**WELWYN HATFIELD BOROUGH COUNCIL  
ASSISTANT DIRECTOR (PLANNING)**

**DELEGATED APPLICATION**

**Application No:** 6/2023/2467/HOUSE  
**Location:** 33 Eddington Crescent Welwyn Garden City AL7 4SX  
**Proposal:** Conversion of loft to form habitable space with insertion of roof lights, fenestration alterations and alterations to openings  
**Officer:** Ms Jessica Fuller

SIDE ELEVATION

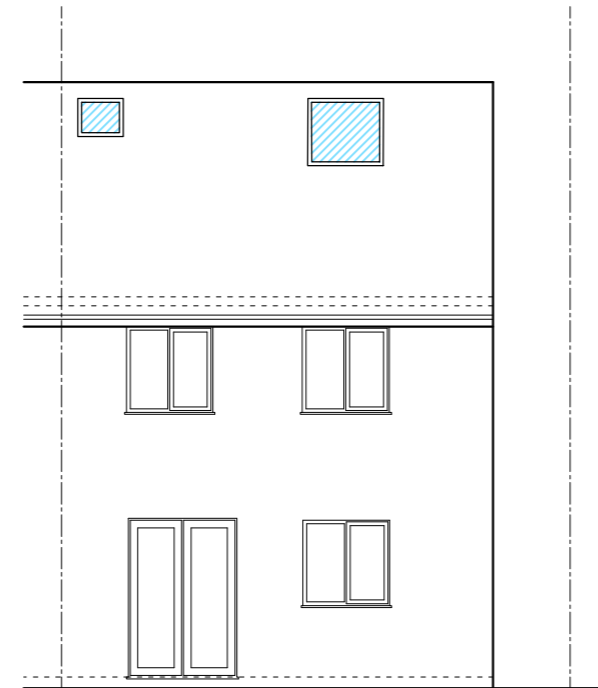
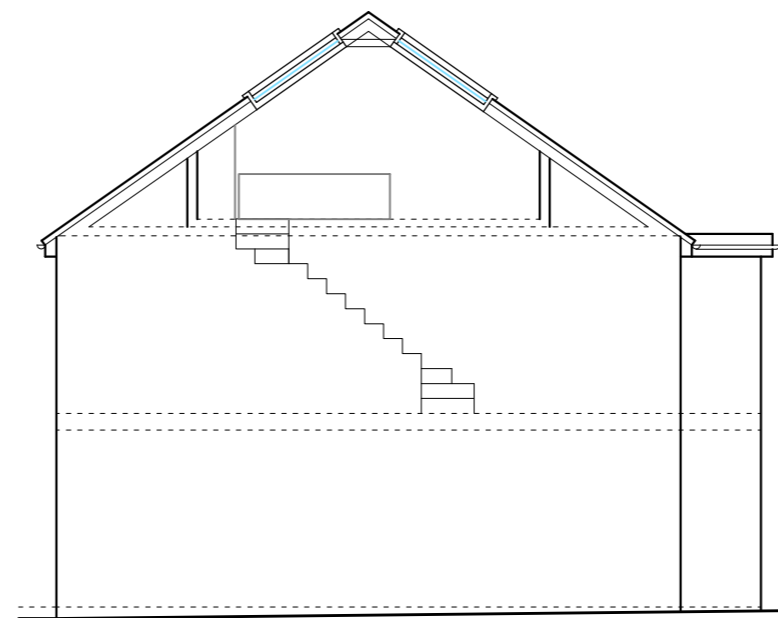
There is potential for the proposed side window to impact neighbouring amenity in terms of overlooking, particularly with regards to number 31 Eddington Crescent as the window would measure approximately 1.4m above floor level and would face towards the rear garden and side elevation of this property. This impact can be overcome by imposing a condition to ensure the window would be obscure glazed and non-opening to protect residential amenity.

2. The proposed side window hereby approved must be obscure-glazed to a level equivalent to Pilkington Level 3 or above and non-opening unless the parts of the window which can be opened are more than 1.7 metres above the floor of the room in which the window is installed, and shall be retained in that form thereafter. Obscure glazing does not include applied film or one-way glass.

ROOF PLAN

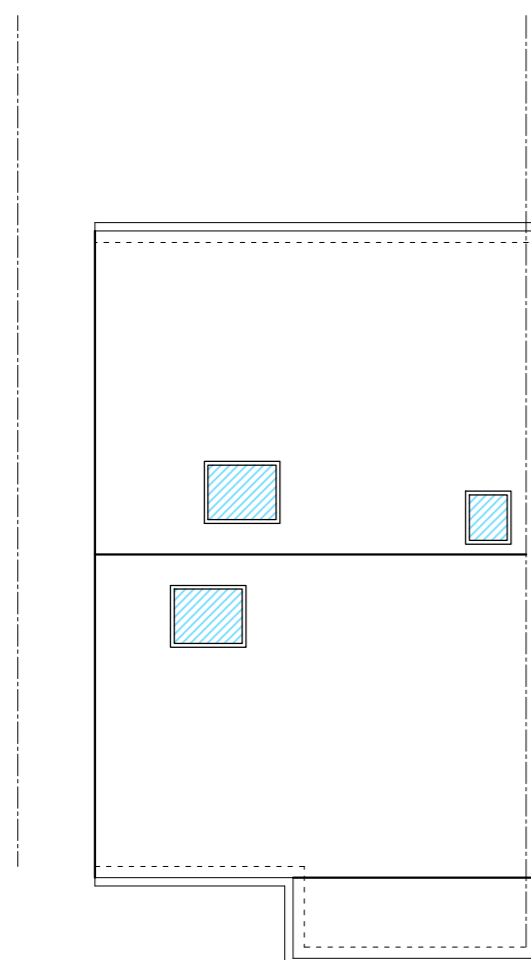
Planning permission is generally not required for internal alterations; therefore, this application will assess the impacts the loft conversion will have on the external appearance of the dwelling, namely the addition of new roof lights and a window. The works would involve the installation of a roof light on the front elevation of the application dwelling, two roof lights on the rear elevation, and a small window on the west facing elevation. These changes would not significantly alter the appearance of the dwelling, with views of the alterations limited within the surrounding street scene. It is considered that these minor changes would not have a detrimental impact on the character of the existing dwelling or surrounding area and would be in accordance with local and national policy.
